CITY OF ALBUQUERQUE

June 5, 2012

Re: Mountain America Credit Union Grading & Drainage Plan, (D20-D010A)
Parcel B, Parcels A, B & C Ventura Plaza (P.E. Stamp: 5/18/12)

SHEET TITLE: GRADING PLAN
SHEET NUMBER: C-201
SCALE: 1" = 20'

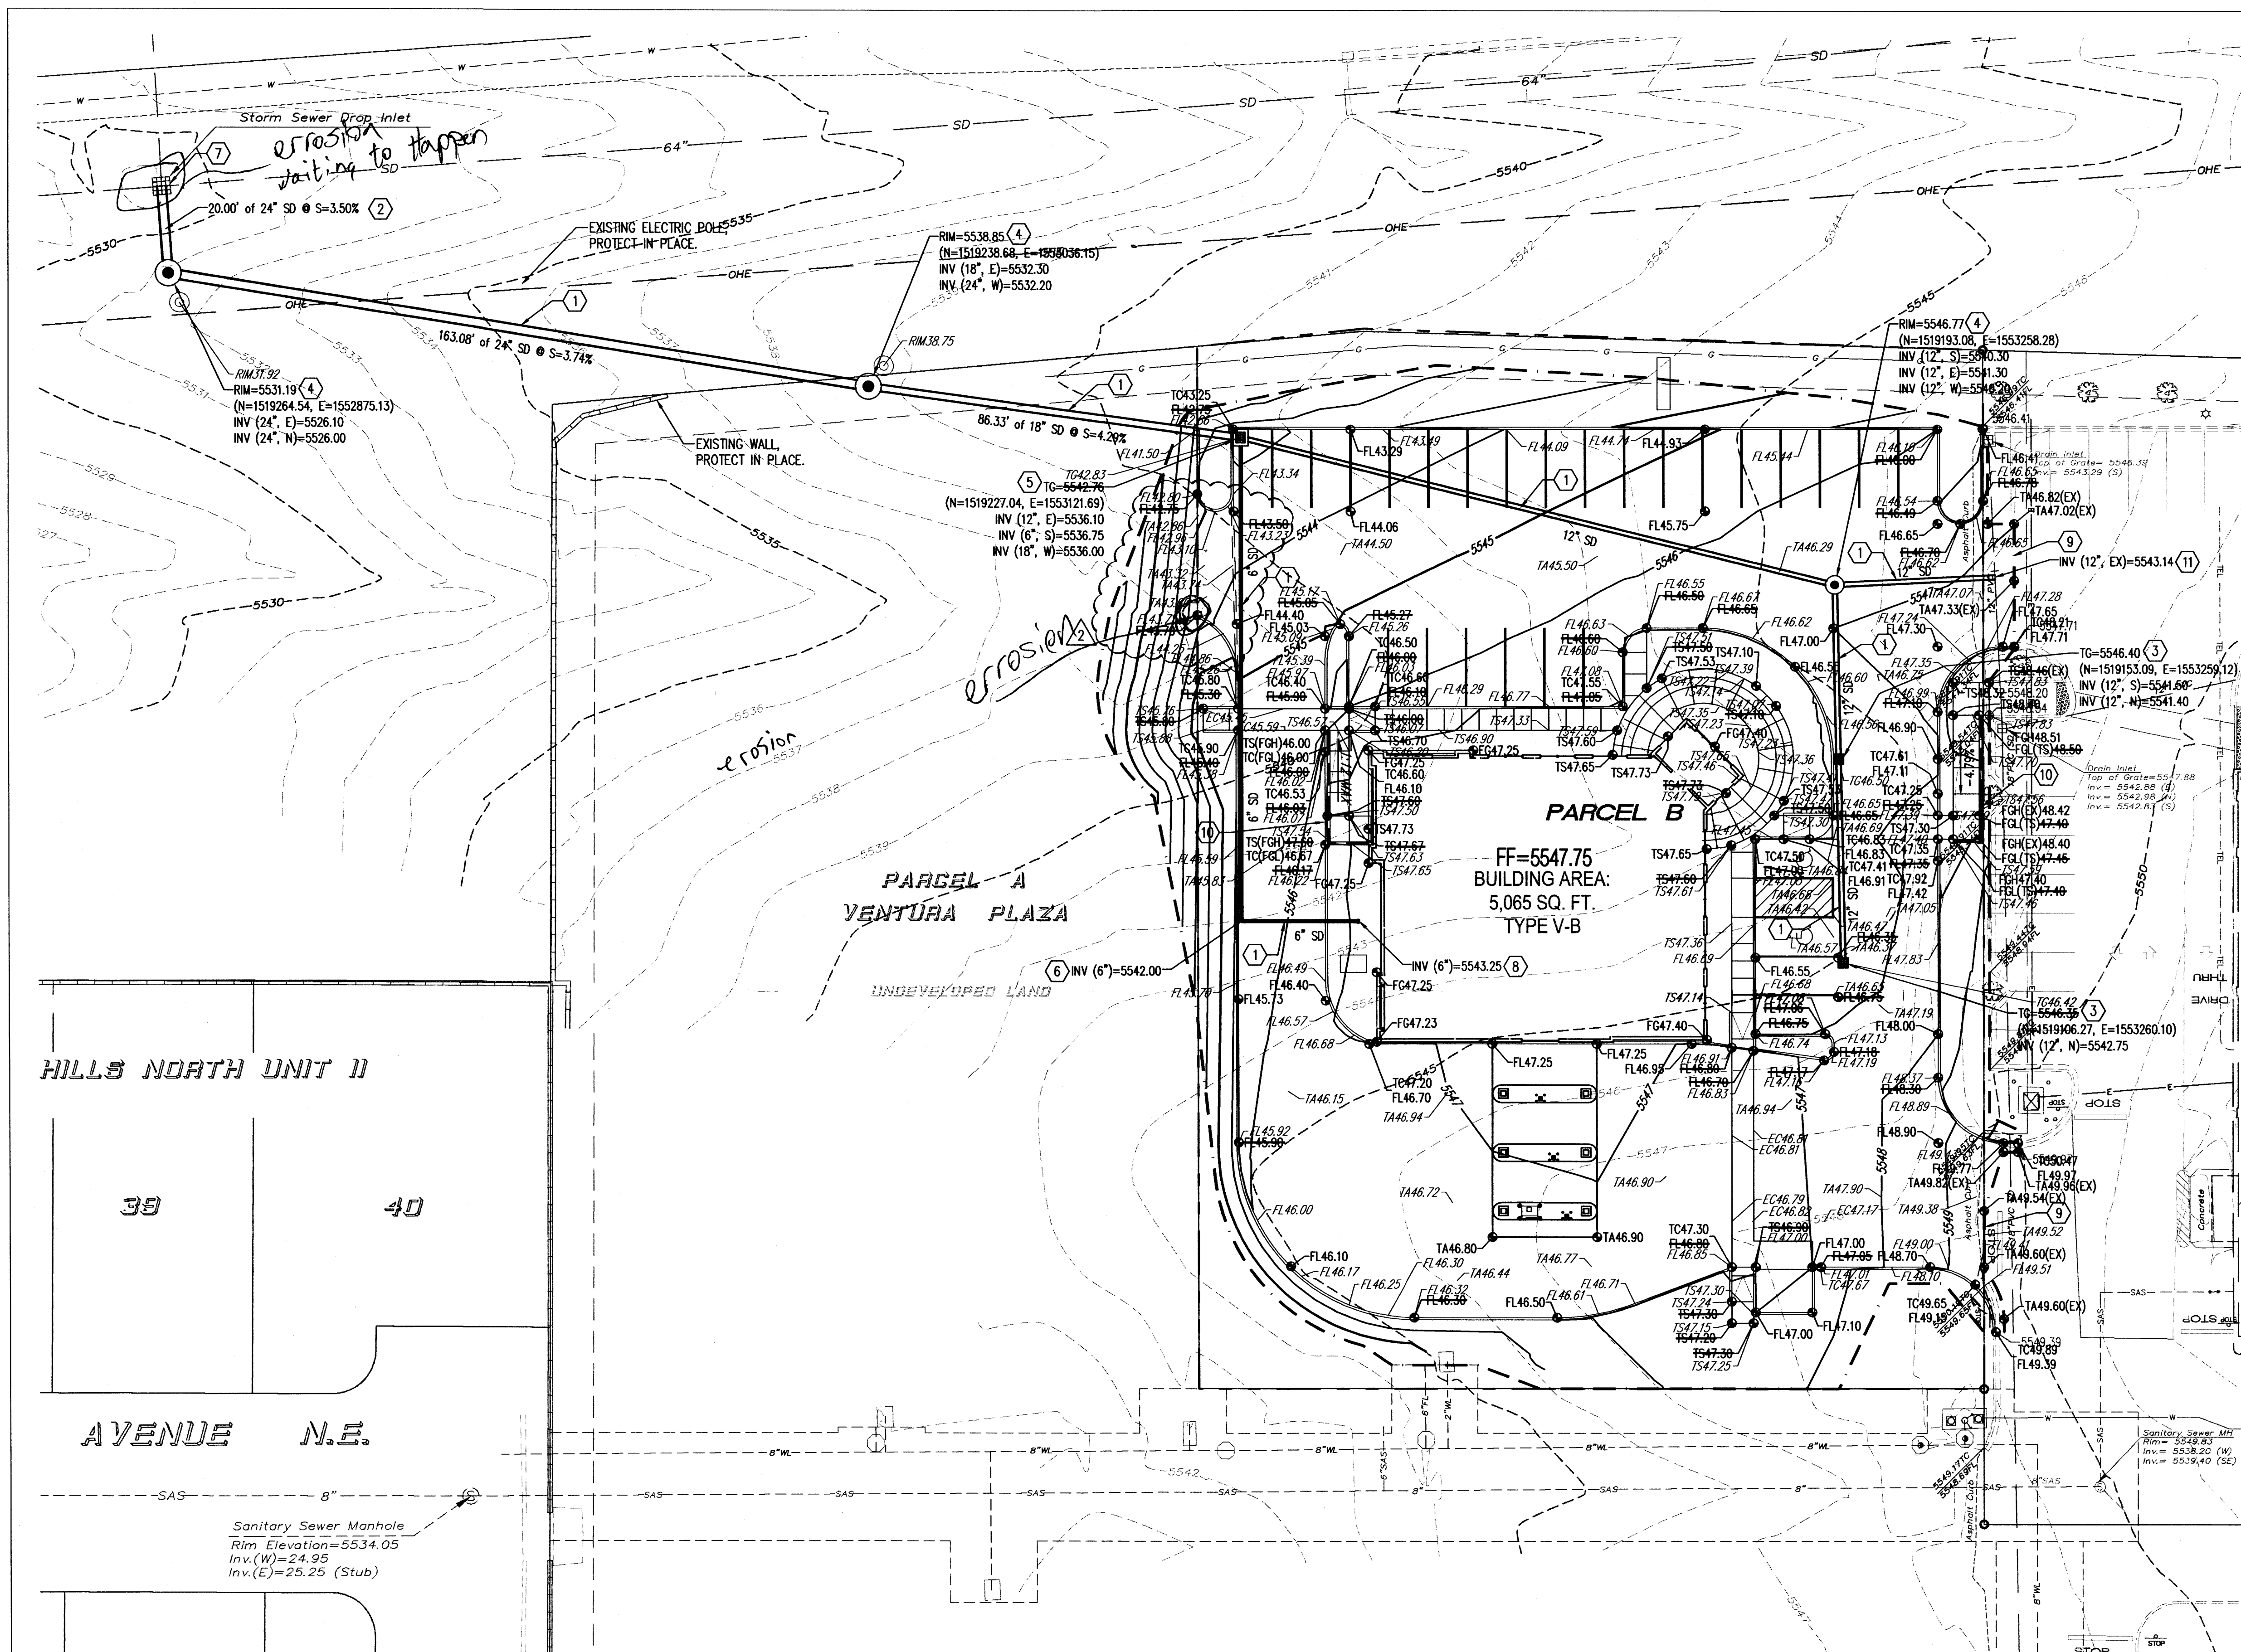
4. This plan lacks a few presentation features required for Grading and Drainage Plans, per the DPM Chapter 22. Please review and update any revised submittal. If DOT approves this plan, I ask that you at least add a location map to the as-built Certification Plan.

SHEET TITLE: **GRADING PLAN**
SHEET NUMBER: **C-201**

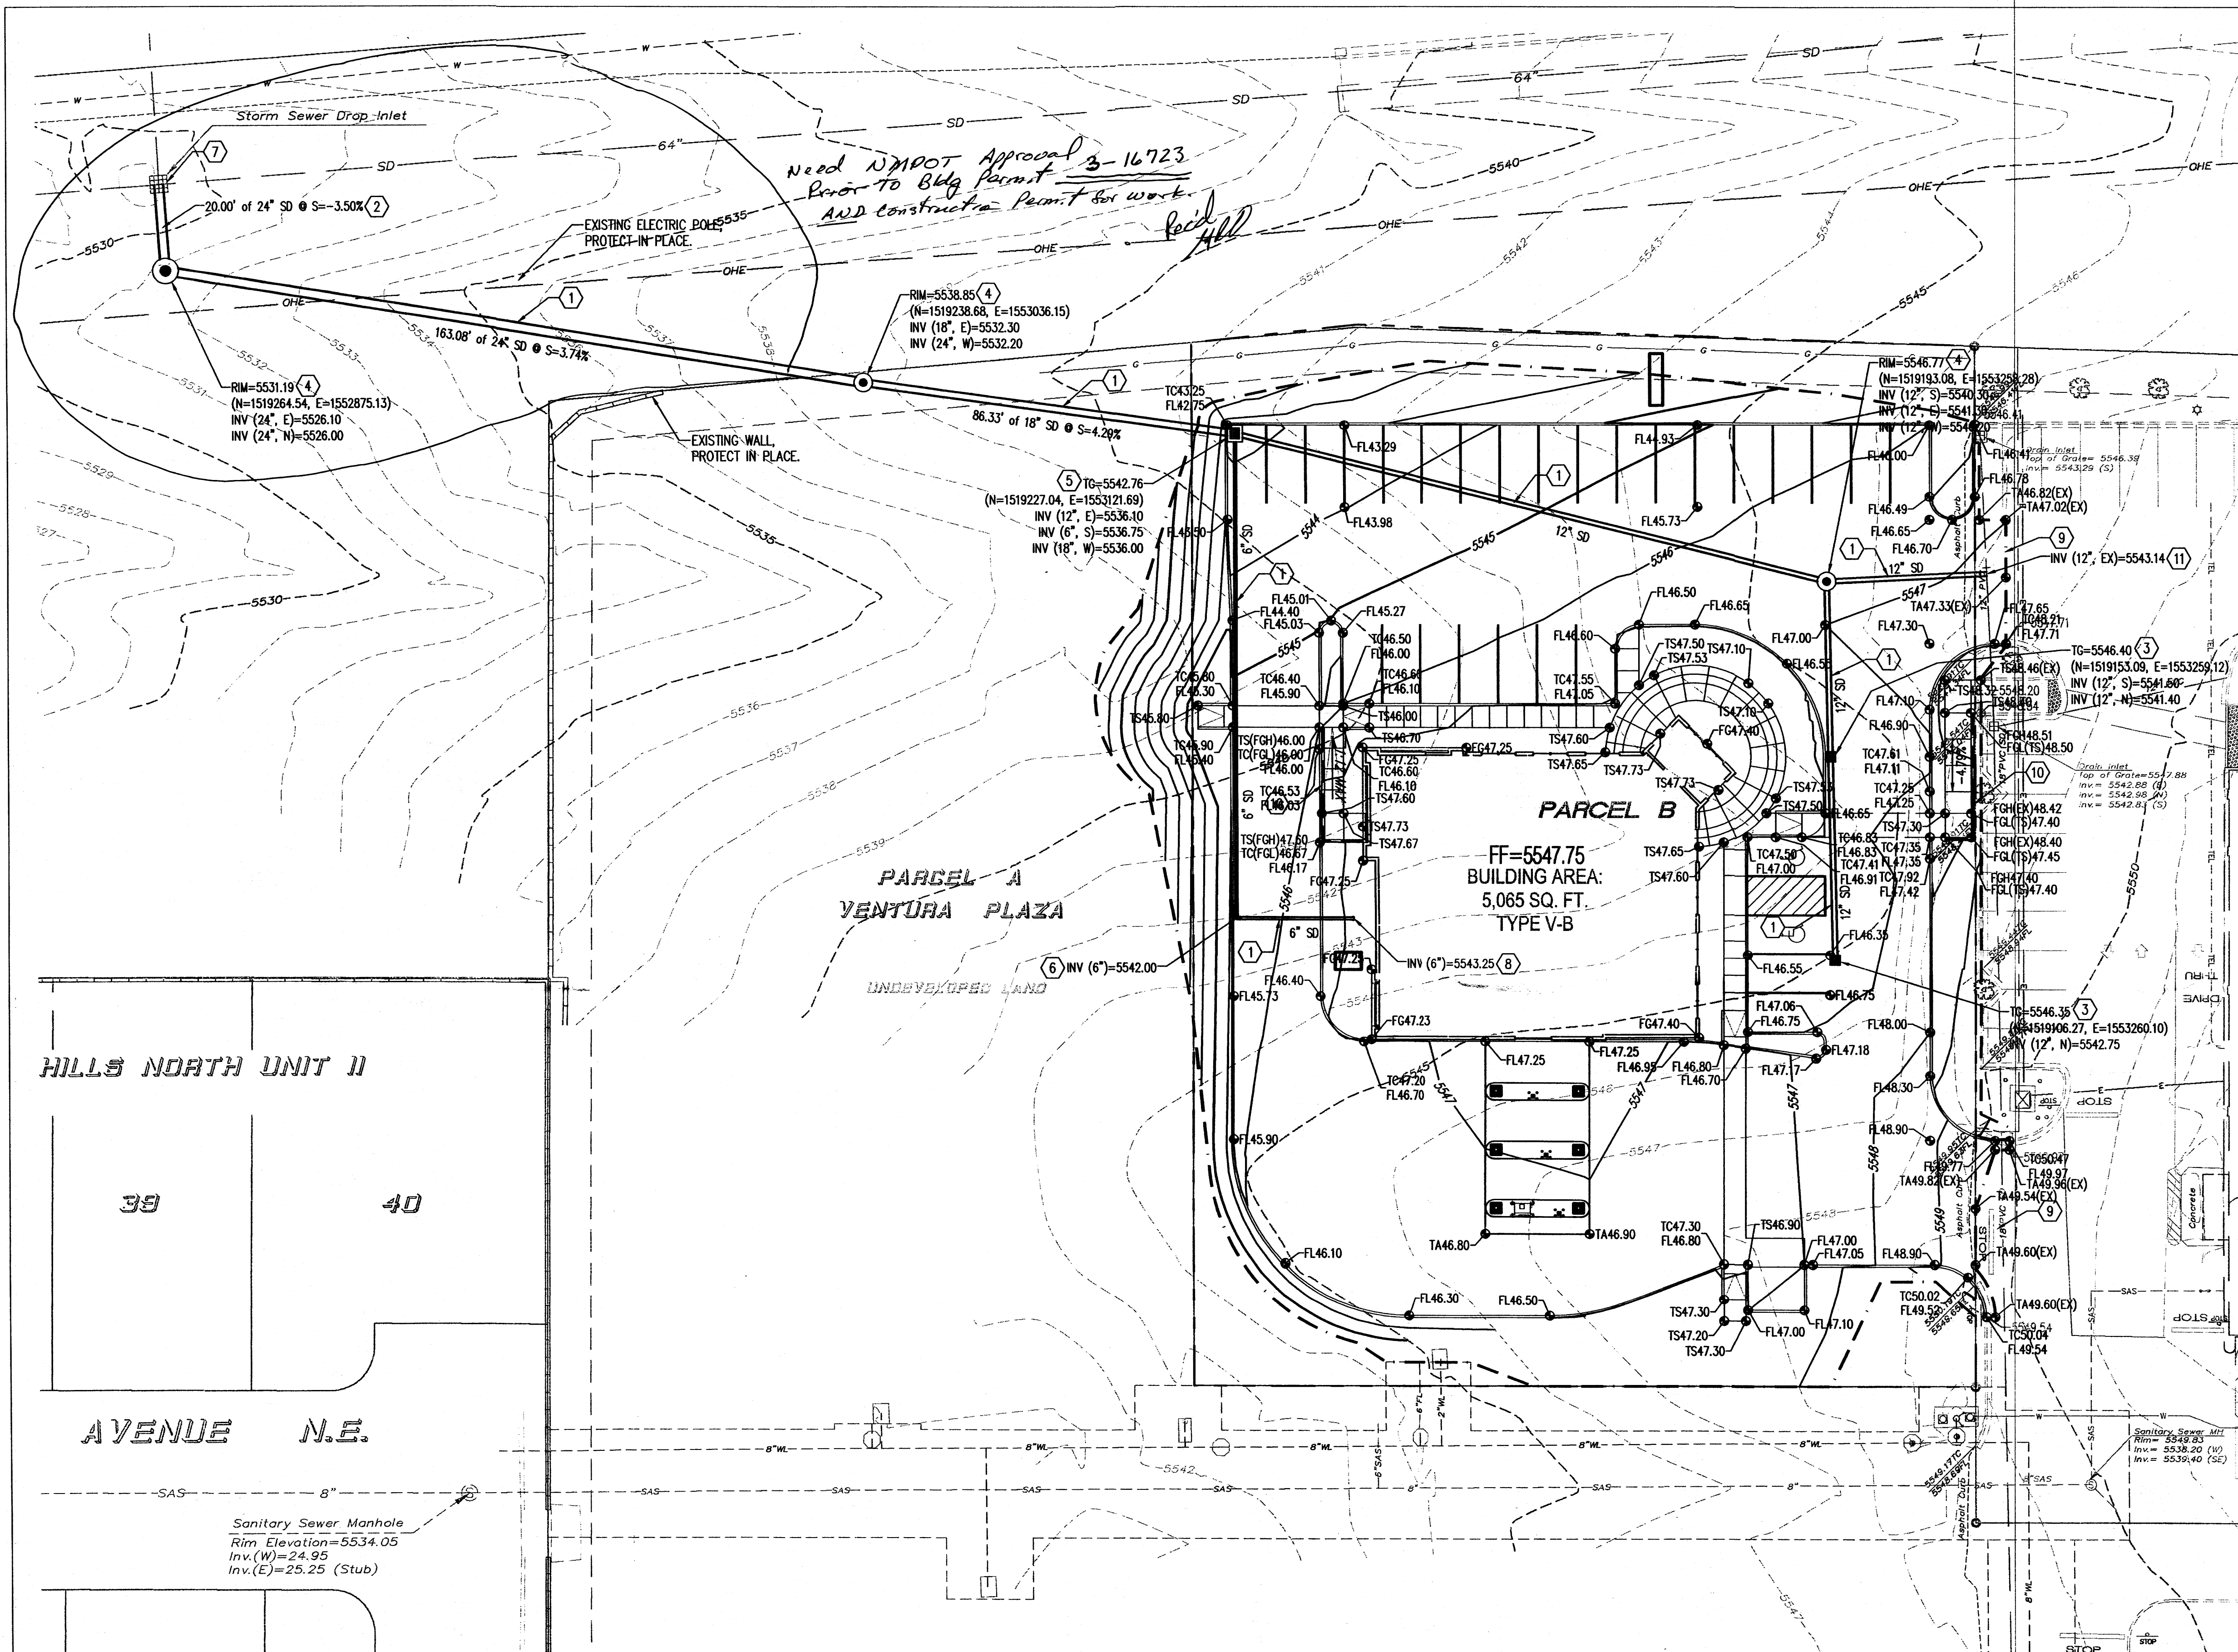
- ✓ 2. Since the 24" storm drain outfall at the NW corner of the site will tie into the 64" storm drain within the Paseo del Norte R/W, it will require approval and a permit from the NM-DOT, District 3. (Contact Timothy Trujillo, Drainage Engineer: 505-798-6690)

- ✓ 3. Prior to City approval of this plan, we require documentation (or email) from NM-DOT of their concurrence with work proposed within their R/W, and citing the PE Signature date on the plan that they approve.
